## Questions posed to the IP's from the ExA

© Crown Copyright and Database Rights 2020 Ordnance Survey 100030649

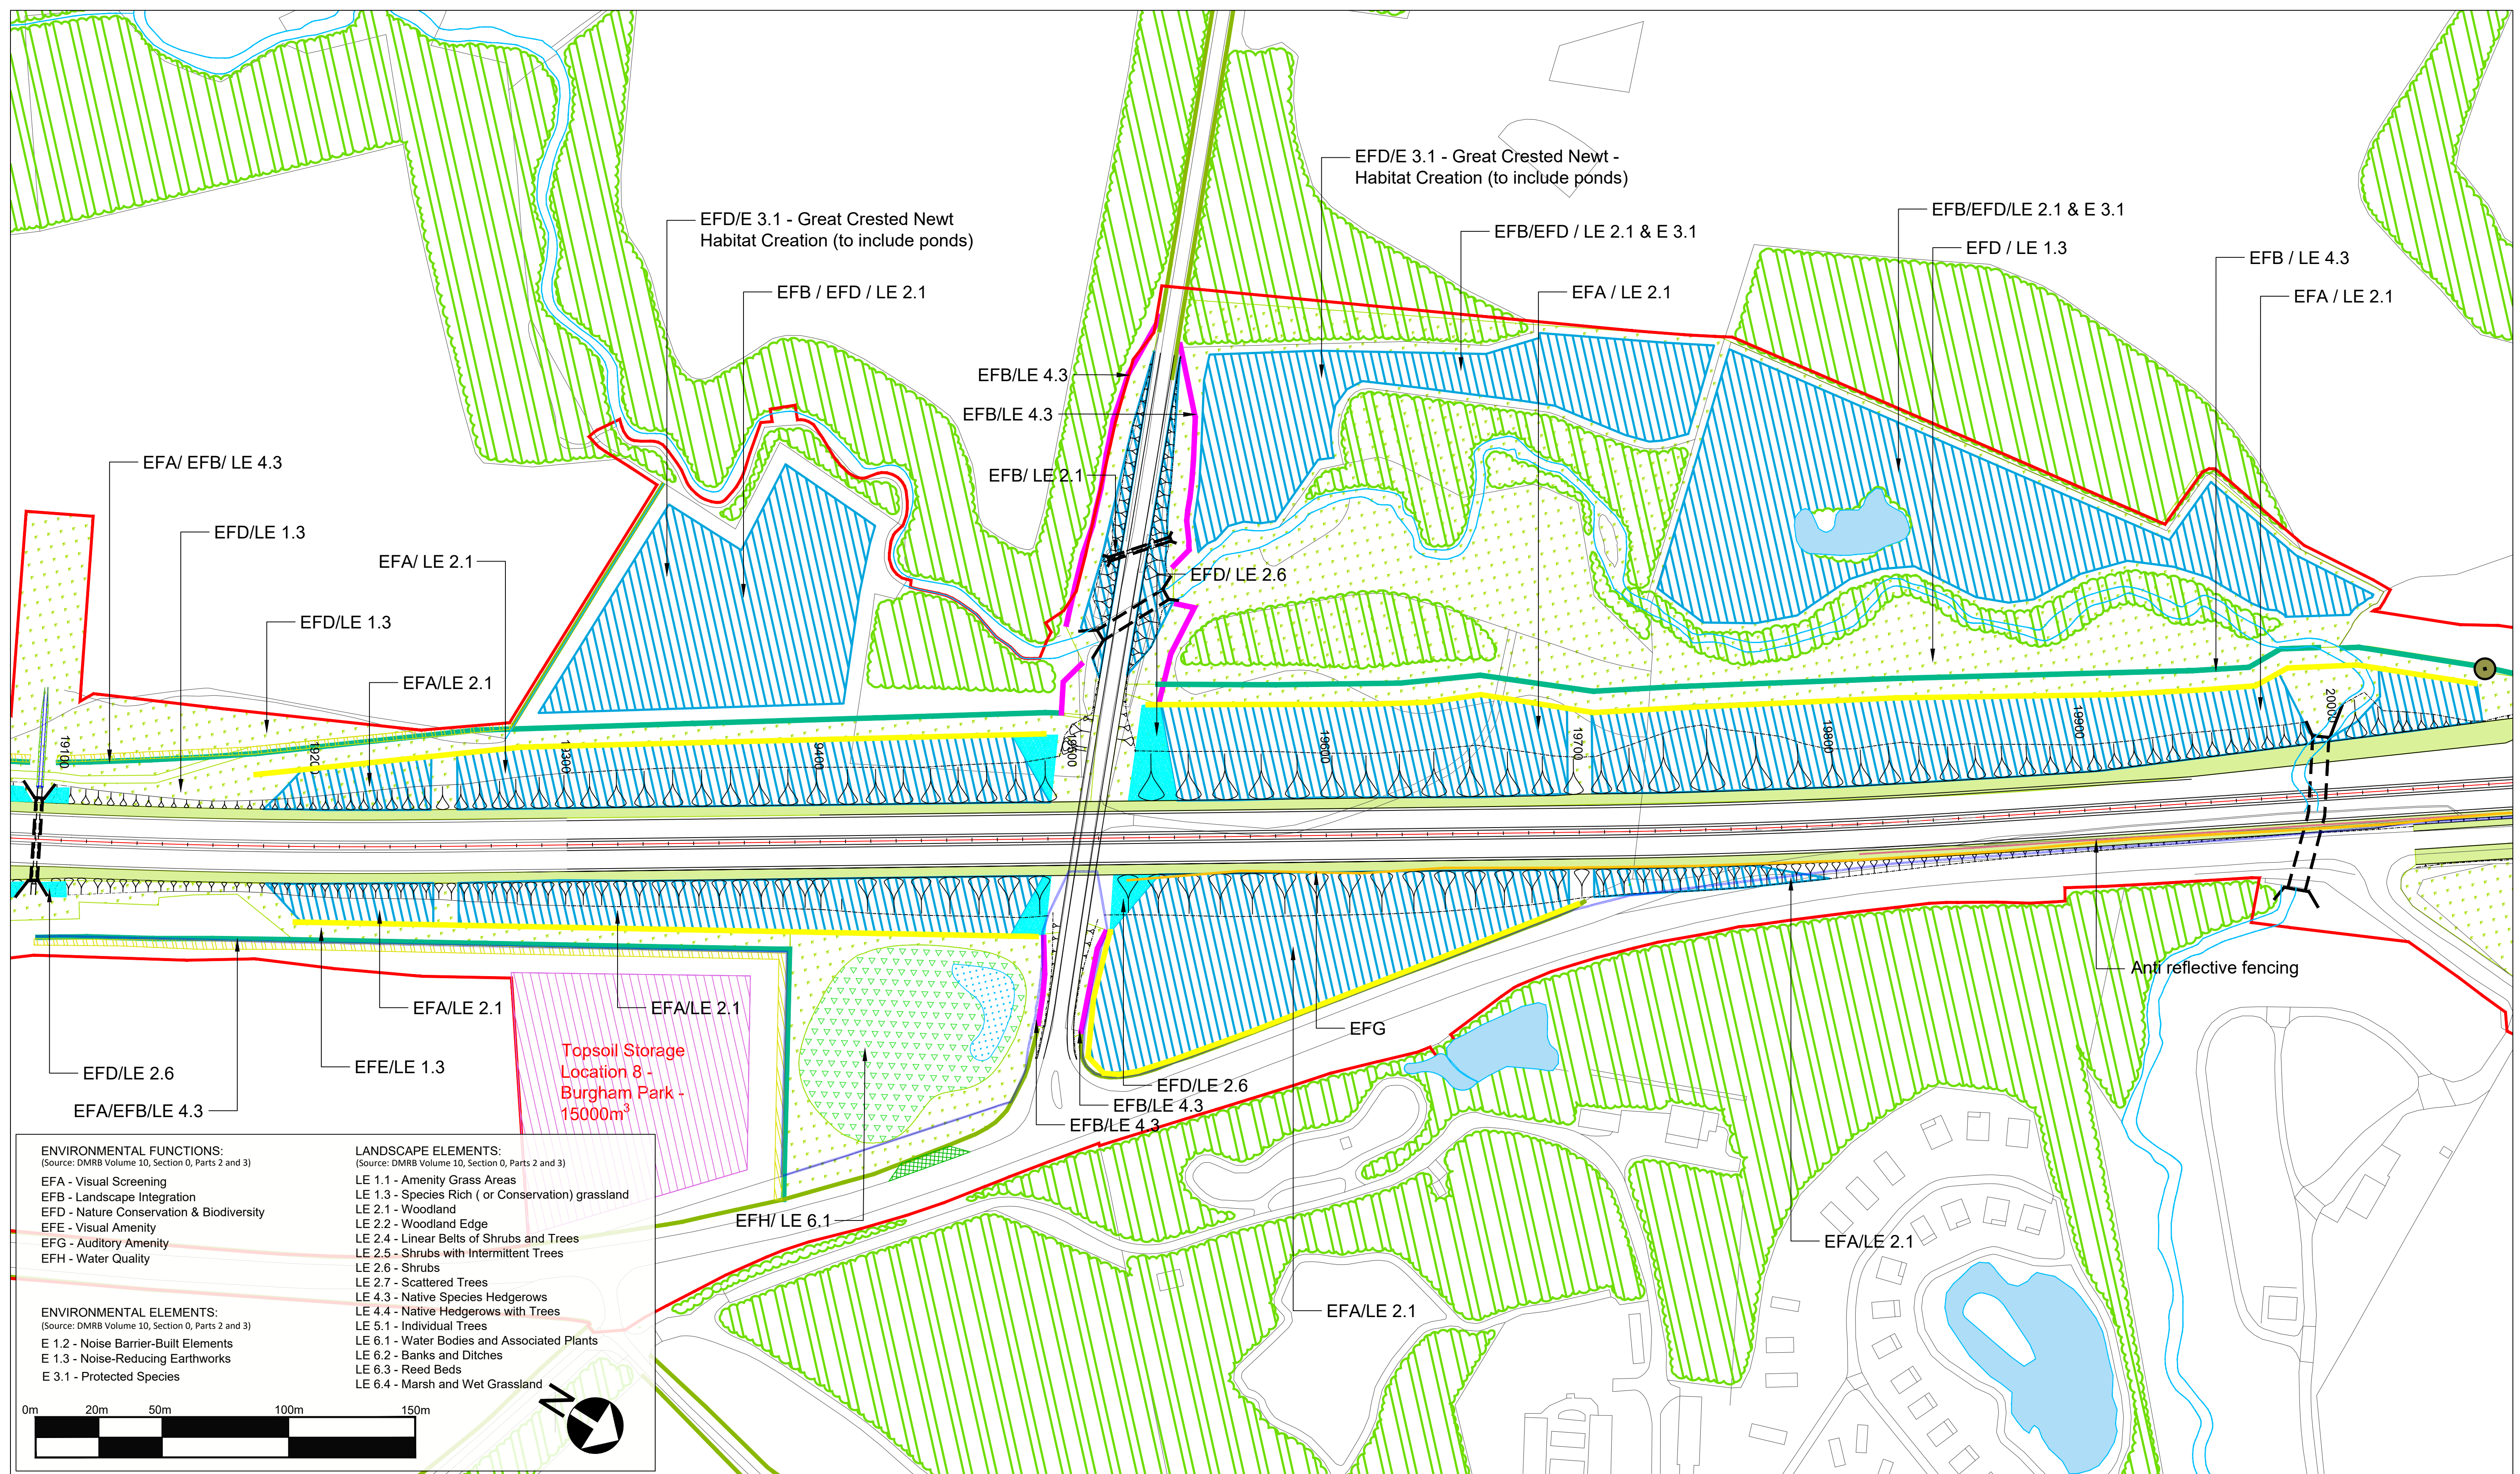
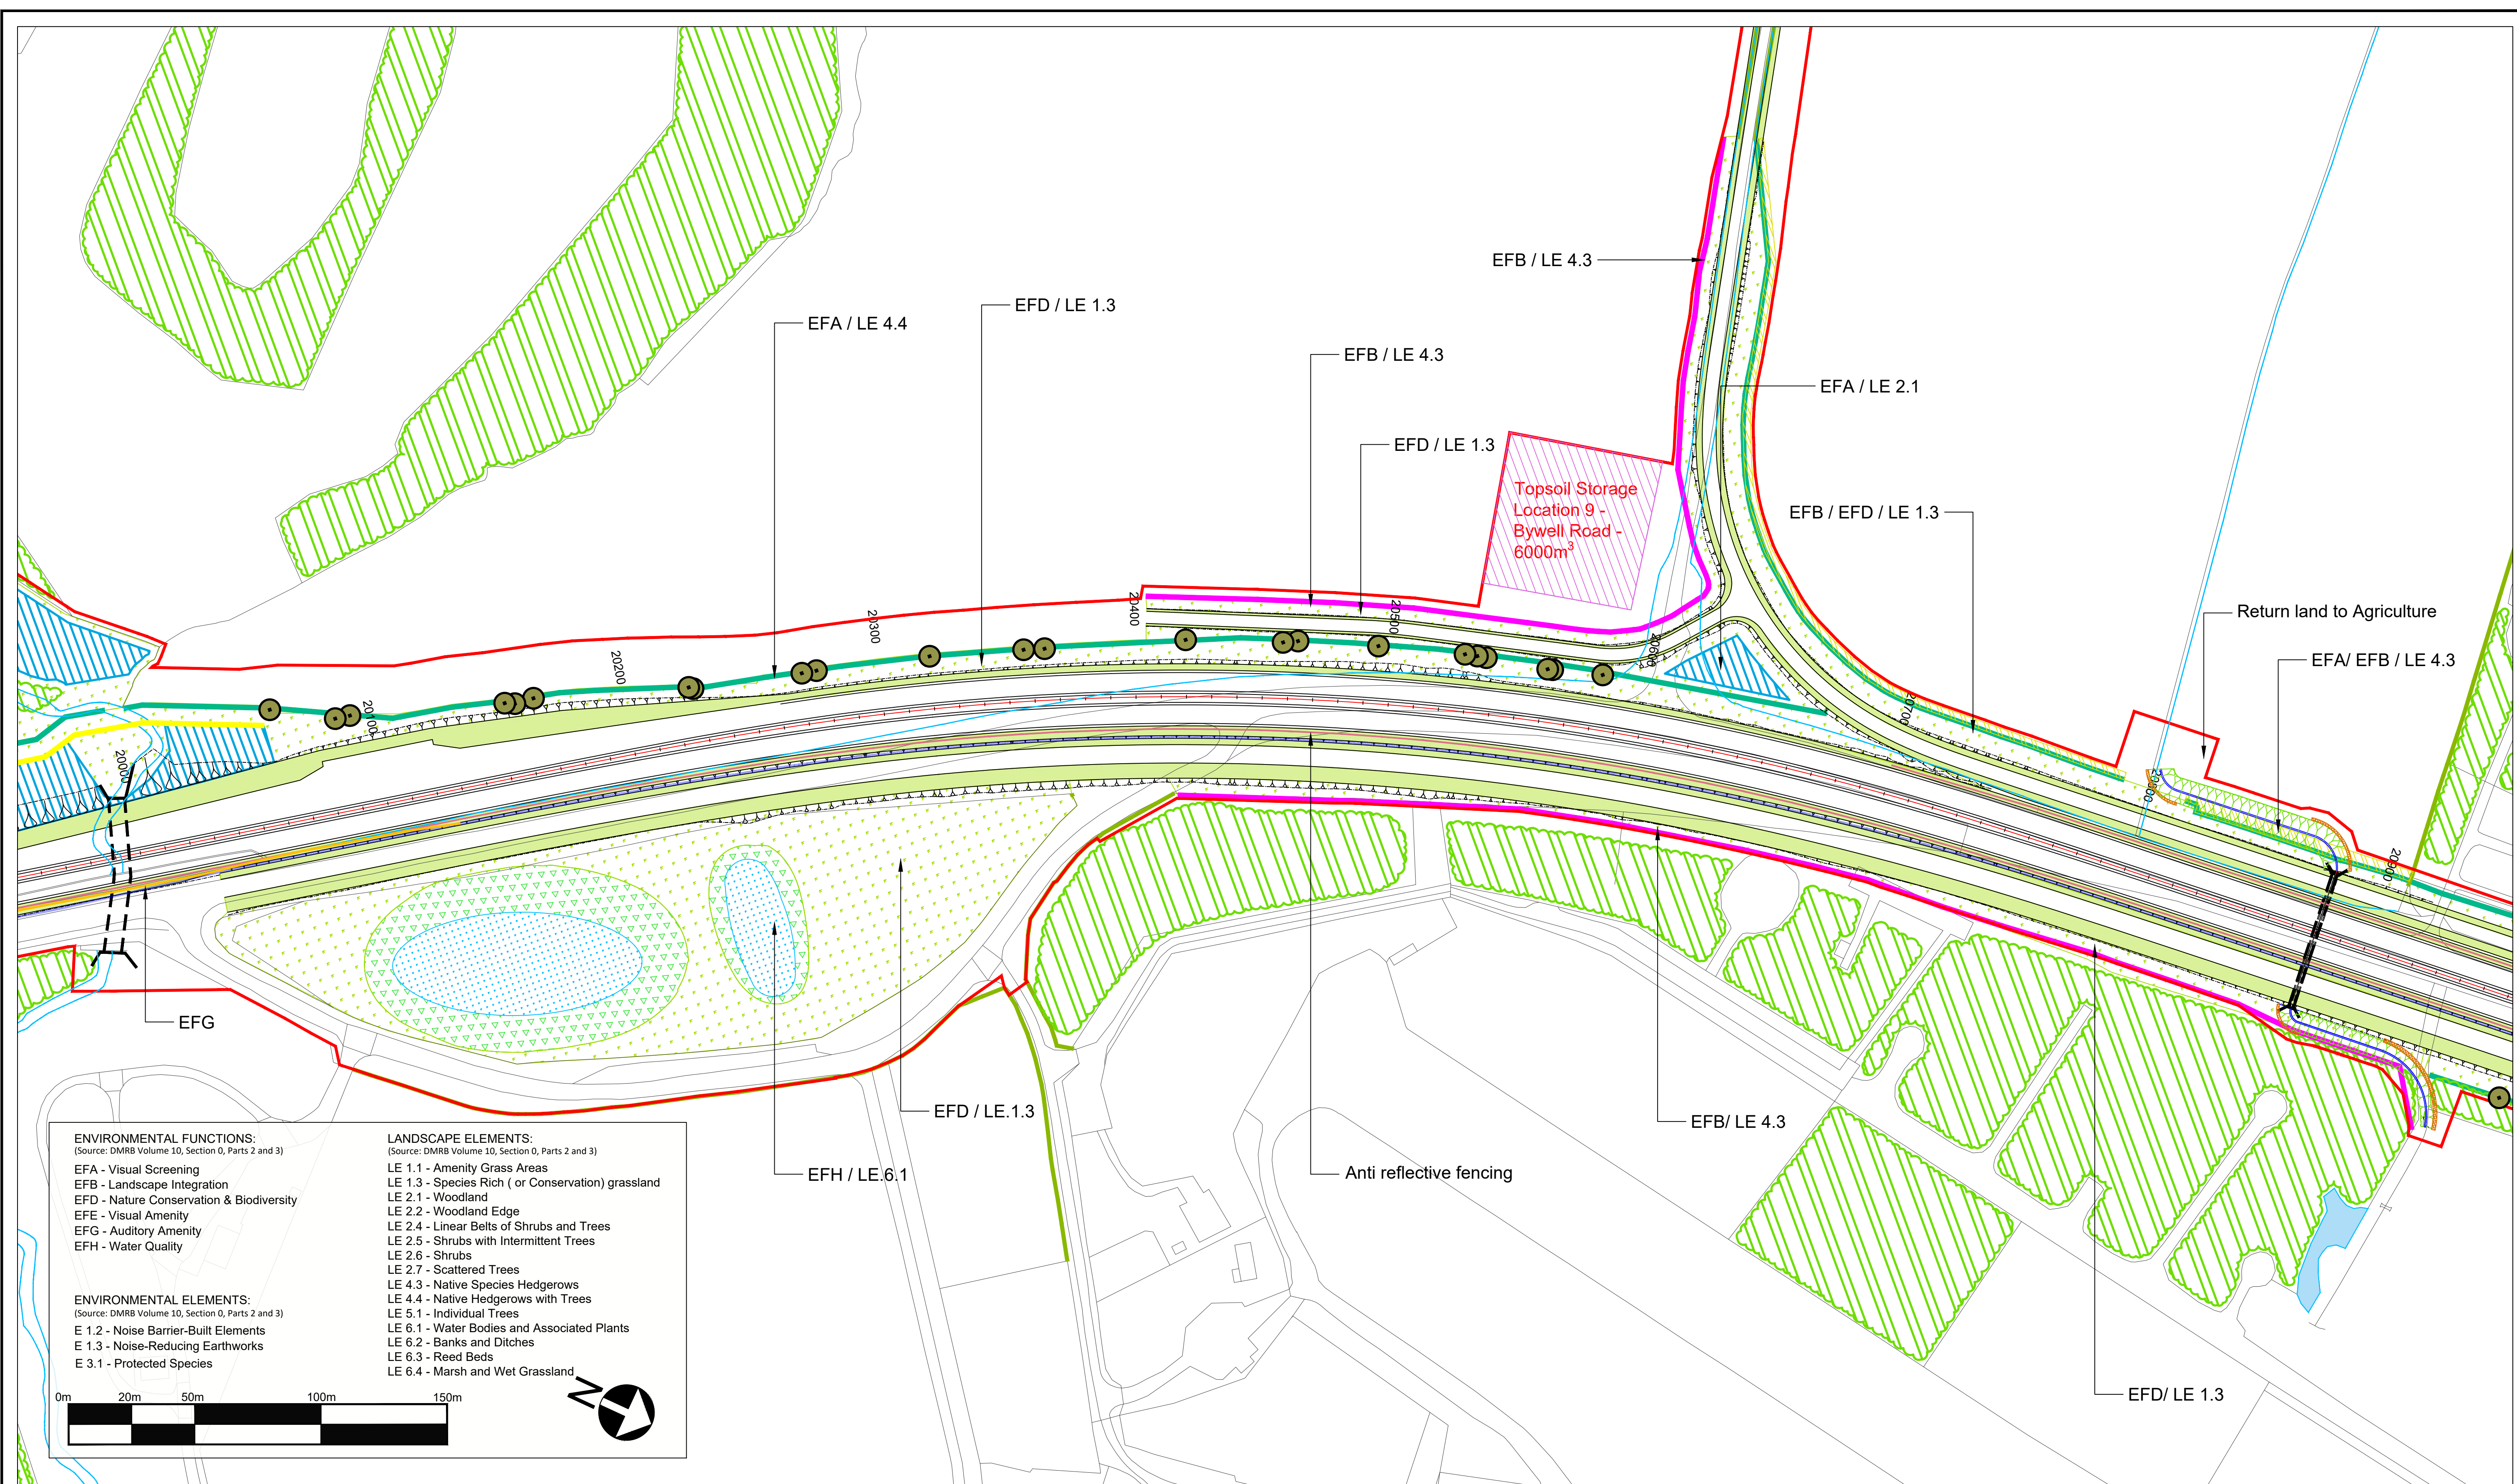
1. Whilst it is positive to see the detail of the landscape mitigation principles, I am struggling to see this approach reflected in the actual plans detailed in APP-095.
2. As I have a number of outstanding queries relating to the Masterplan, I would welcome further detail and context provided by a landscape and ecological management plan.
3. As the current plans involve major detrimental changes to the landscape that I currently enjoy I have raised a number of concerns and queries with the Applicant on this topic in May 2020 which remain outstanding. I am hopeful that a scheduled meeting with the Applicant will help answer the queries.

1. Unfortunately, the Landscape Mitigation Masterplan shown in APP-095 is a major source of frustration and disappointment as I believe that it falls well short of what should be achieved to address landscape and ecological features.

2. In considering my property, as an example, the plans involve major changes to the to a picturesque landscape on all sides of the property. The current outlook from my property which includes mature woodlands and a pleasant tree lined avenue is to be replaced with 7 lanes of tarmac including a layby and access roads. The Landscape Masterplan offers very little mitigation to offset the detriment to visual effect. The sense of frustration is further exacerbated when the impact on the landscape visual is categorised as being slight.

1. As the plans involve major detrimental changes to the landscape that I currently enjoy I have raised a number of concerns and queries with the Applicant on this topic in May 2020 which remain outstanding. As some of my queries relate to the use of keys in the plans, I would welcome any additional information to help my understanding.
